KIRKLEES METROPOLITAN COUNCIL INVESTMENT & REGENERATION SERVICE

DELEGATED DECISION TO DETERMINE PLANNING APPLICATION FOR ADVERTISEMENT CONSENT

Reference No:	2026/64/90572/W
Site Address:	Pavement o/s, utilita, Ramsden Street, Huddersfield, HD1 2BQ
Description:	Advertisement Consent for installation of 1 BT Street Hub, incorporating 2 digital 75inch LCD advert screens, and associated BT Phone Kiosk removal (within a Conservation Area)
Recommending Officer:	John Holmes

DECISION – Advertisement Consent - Refused

Drawing Number	003	Revision	A
-----------------------	-----	-----------------	---

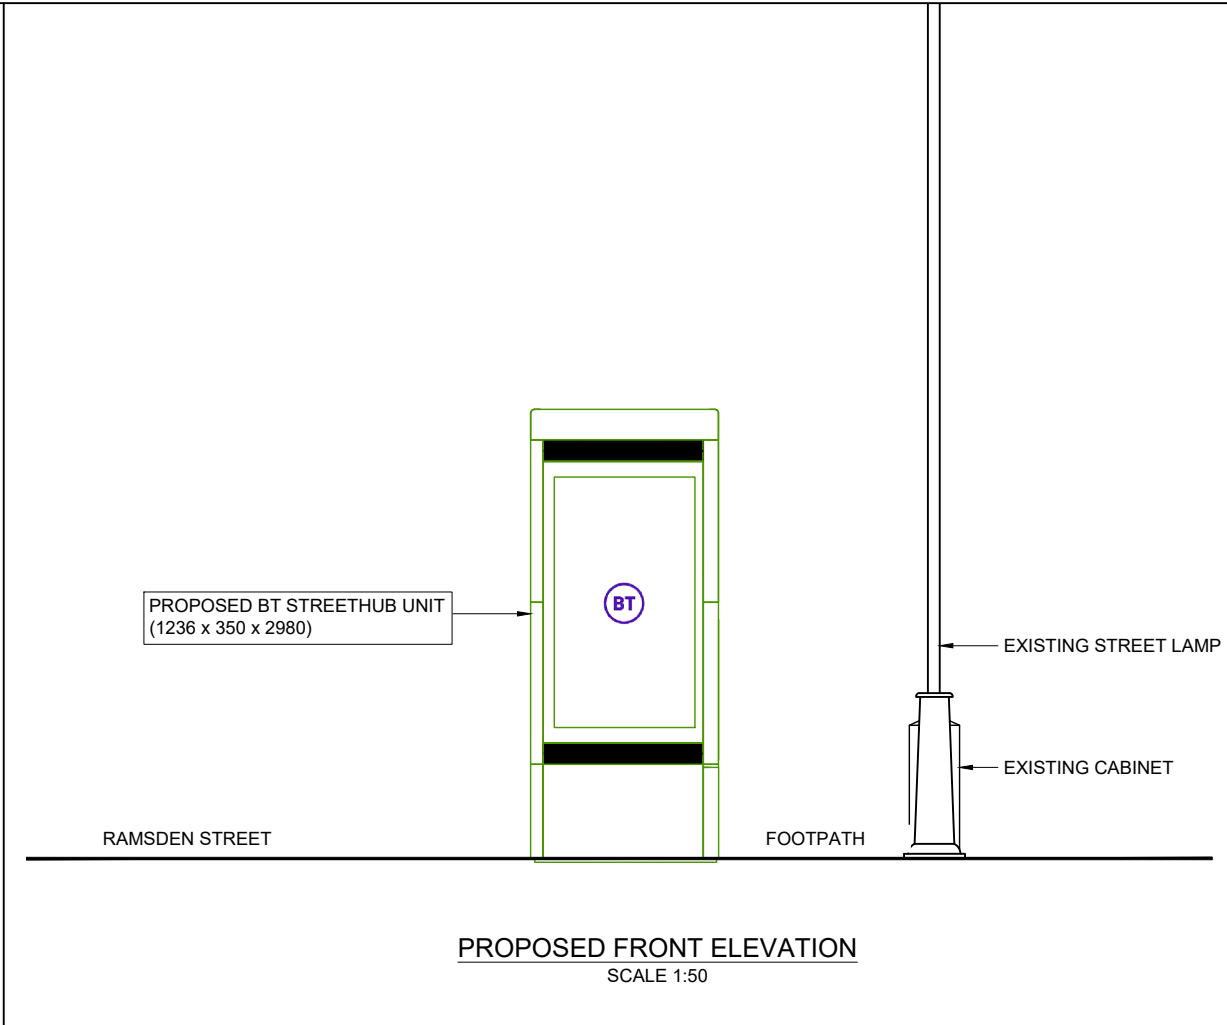
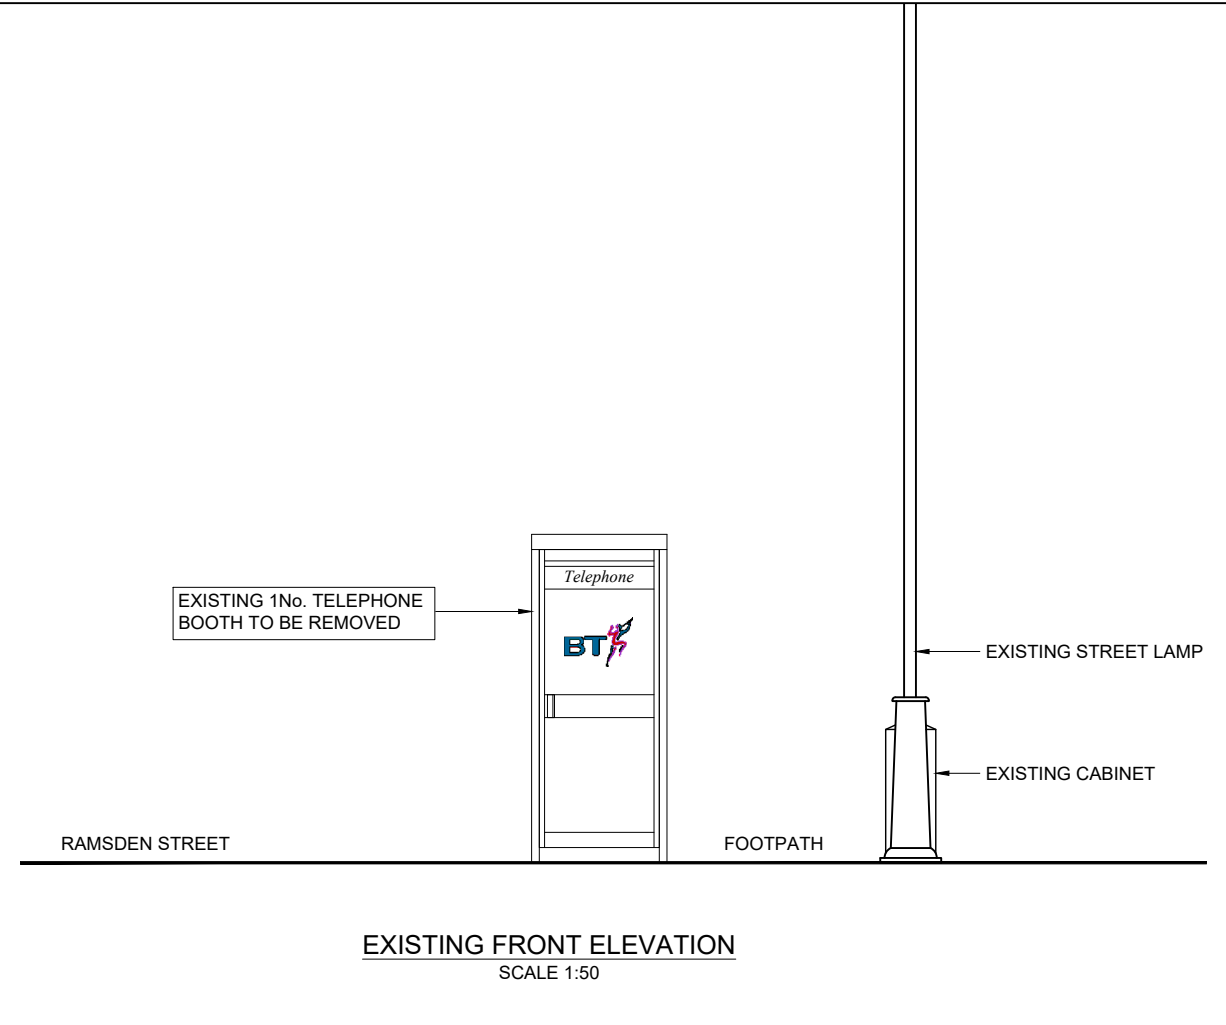
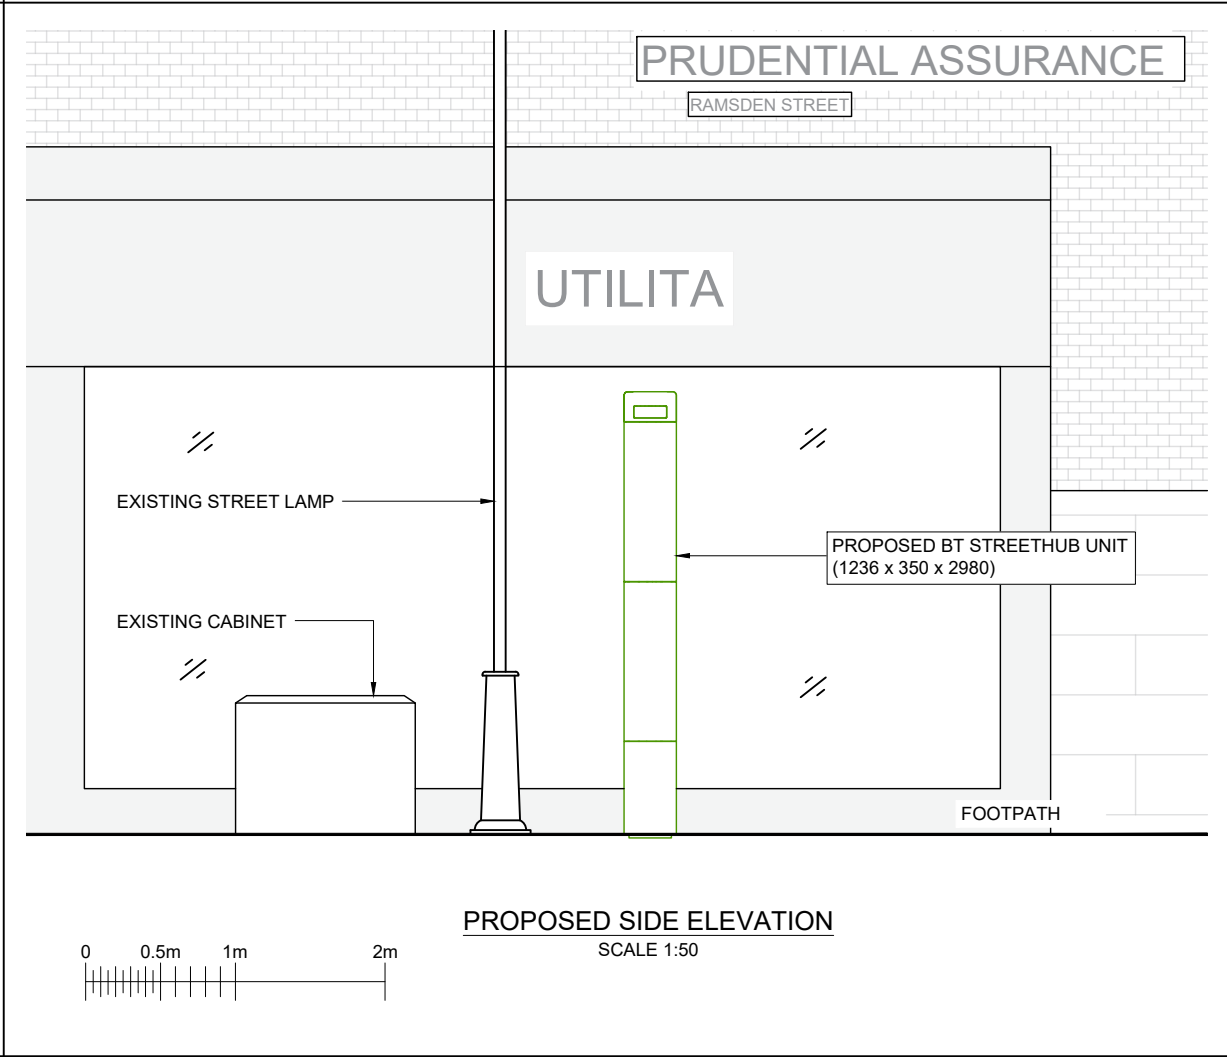
The proposed signage would be a maximum height of ~3m high and would be highly visible within the street scene as it is sited in a prominent location on the footway. This prominence would be compounded by the advertising display on each side of being internally illuminated. The Conservation Officer considered that the introduction of prominent internally digital display screens would be a visually intrusive and unattractive feature that would not harmonise well with the character of this part of the Conservation Area, and would neither preserve or enhance its significance in the consideration of the previous refusal at the site. It is also considered that the signage would be discordant to the setting of the Grade II listed buildings of 71 New Street, Huddersfield Town Hall, Queensgate Market and 62 New Street and would therefore cause harm to their significance.

The visual impact of the display screens upon the visual quality of the Town Centre more generally must be given consideration, having regard to the cumulative impact of similar installations already in existence. An existing advertising unit, illuminated on the west side, is situated around 8m away on the opposite side of Ramsden Street, albeit outside the Conservation Area. In addition to this, on High Street to the west are three more digital advertisement display units around 80m away (again, outside the Conservation Area), along a further one on New Street. Given this, the Council's Conservation Officer and Officers hold the view that the proposal would add further illuminated street clutter which would detract from the character of the area and cause cumulative harm.

The removal of a single phone box would be a modest enhancement to the Conservation Area and the wider Town Centre. However, the introduction of a further pair of display panels would add further illuminated street clutter which would, especially in the context of already existing digital display screens, detract from the character of the area and cause cumulative harm. It would thereby conflict with both Huddersfield Blueprint initiatives mentioned above.

In conclusion, the proposed illuminated display panels would cause detrimental harm to the visual amenities of the locality and less than substantial harm to the significance of nearby Grade II listed buildings and the Huddersfield Town Centre Conservation Area. The proposal is therefore contrary to the aims of Policies LP24(a), LP25 and LP35 of the Kirklees Local Plan, Chapters 12 and 16 of the NPPF, advice within the PPG regarding amenity considerations and the Council's duty under Sections 66 and 72 of the Planning (Listed Buildings and Conservation Areas) Act 1990, which states that Local Planning Authorities shall pay special attention to the desirability of preserving or enhancing the appearance of buildings or land within a Conservation Area, and the setting of any Listed Building.

SITE LOCATION

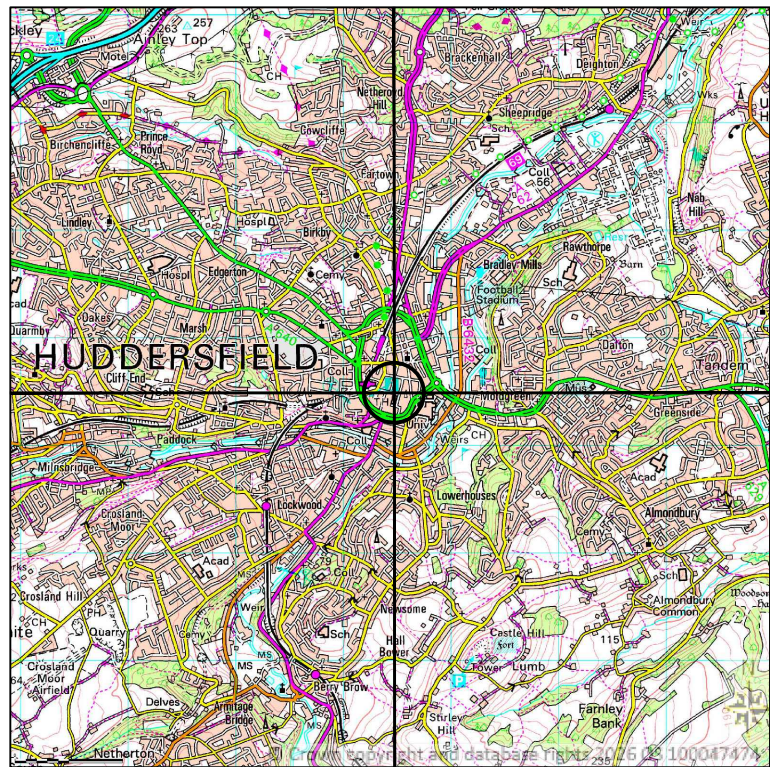
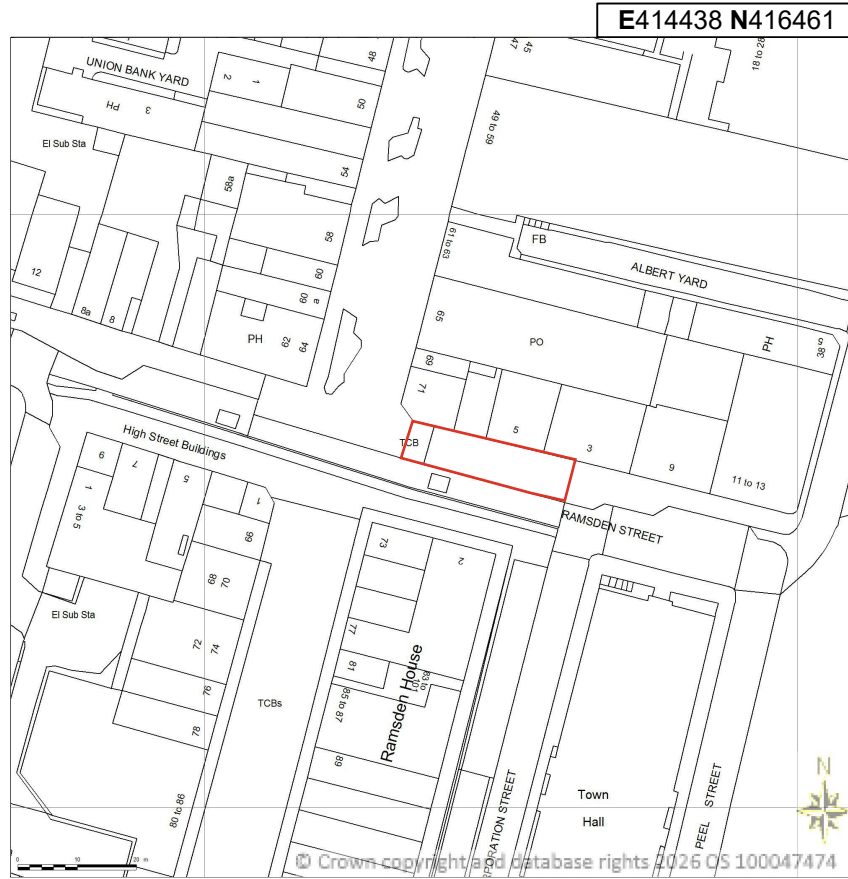
Clarification Note: Submitted plan (ref 001RevA) includes two site location plans at scale 1:1250 which show different sites. This application is assessed on the basis of the top plan (E414438N416461) as this relates to the site with the same address upon the submitted form.
